Notice of Exhibition of application for Marist Catholic College North Shore (SSD-10473) (North Sydney)

Thank you for your referral dated 19 February 2021 inviting comments from the Heritage Council of NSW on the above Marist Catholic College North Shore (SSD-10473) (North Sydney) proposal.

As delegate of the Heritage Council of NSW, the following comments are provided:

**Figure 12: Trees proposed to be retained and removed**

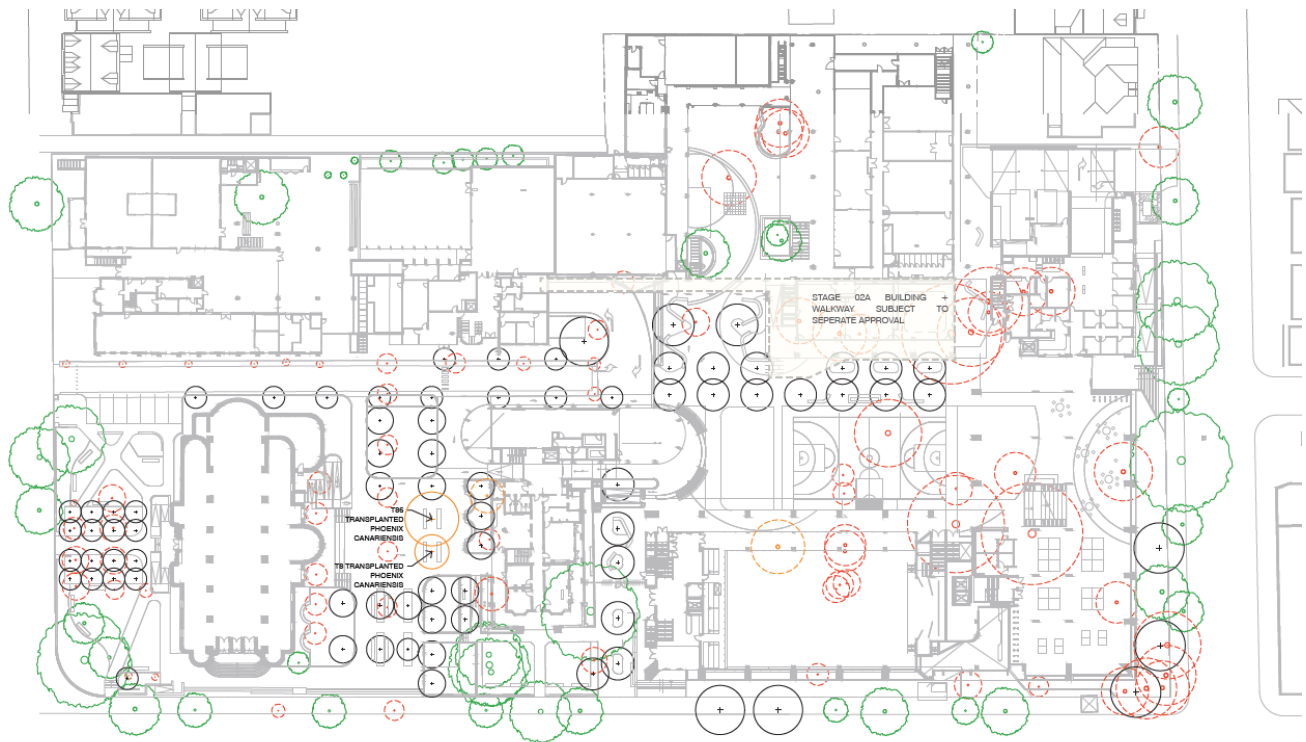
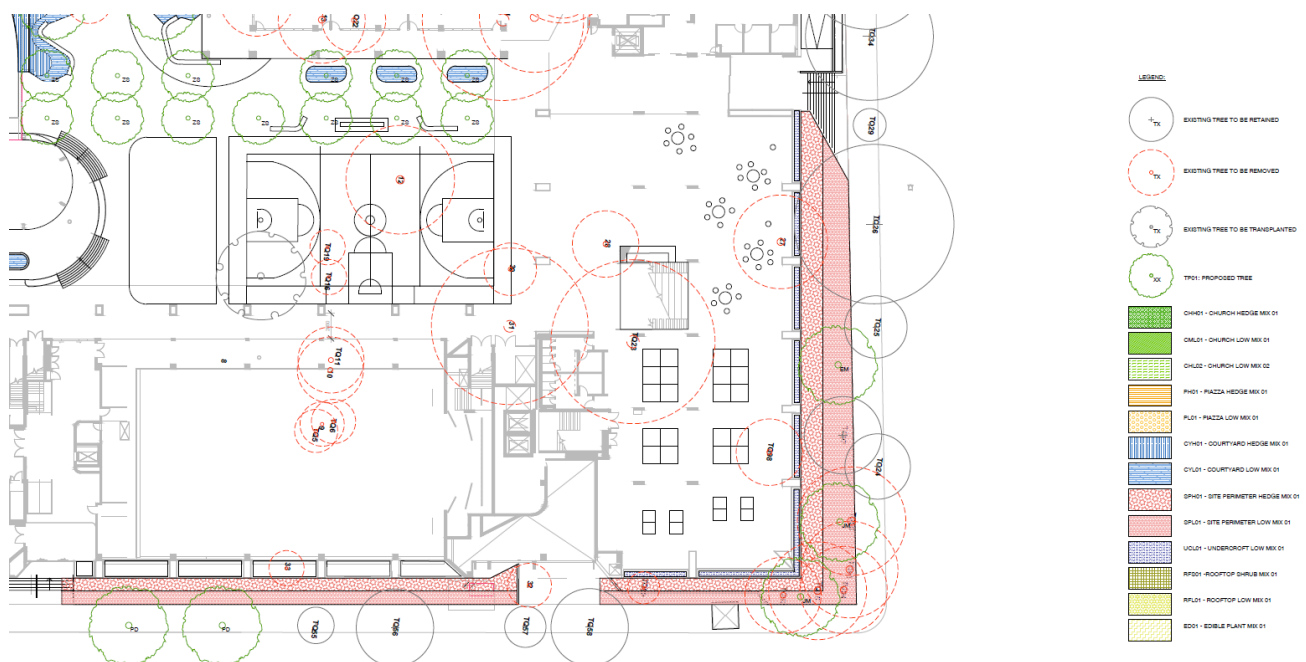
3. The Visual Impact Analysis states that ‘views of the proposal may be visible from within the north-west quadrant of St Leonards Park, in particular the formed pedestrian path that traverses the park in a north-east to south-west direction (VIA, p10). The proposed Curlow Building at the corner of Miller and Curlow Street requires the removal of green space that supports a group of high and moderate significance trees, including a mature *Jacaranda mimosifolia* (Jacaranda) (Tree TQ96) 14 metres in height. This corner is located directly opposite the key entry point to the park and the view along the axial path running east west through the park (CMP, p44). The narrow setbacks to Miller Street associated with the proposed building and the proposal to offset with roof plantings, fails to preserve existing vegetation or allow for suitable deep rooted landscaping such as trees that would sufficiently mitigate the bulk and scale of the proposed development and preserve the landscape character of the locality (Figure 12 and 13, VIA, p21 and 22).

Artists Impression at Corner Miller and Carlow Streets

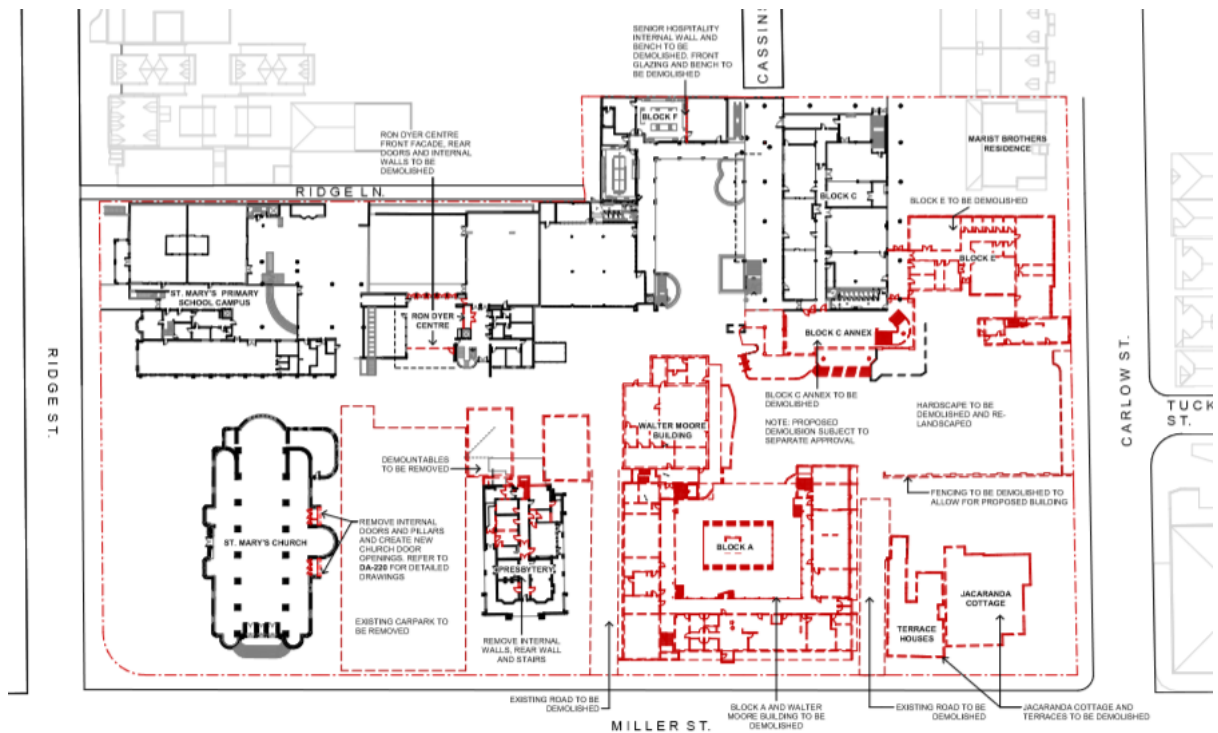
5. Based on the above, the building setbacks and loss of green space at the corner of Miller and Curlow Street is considered unsympathetic to the existing heritage values of the locality and streetscape and it will adversely impact views to and from St Leonards Park.
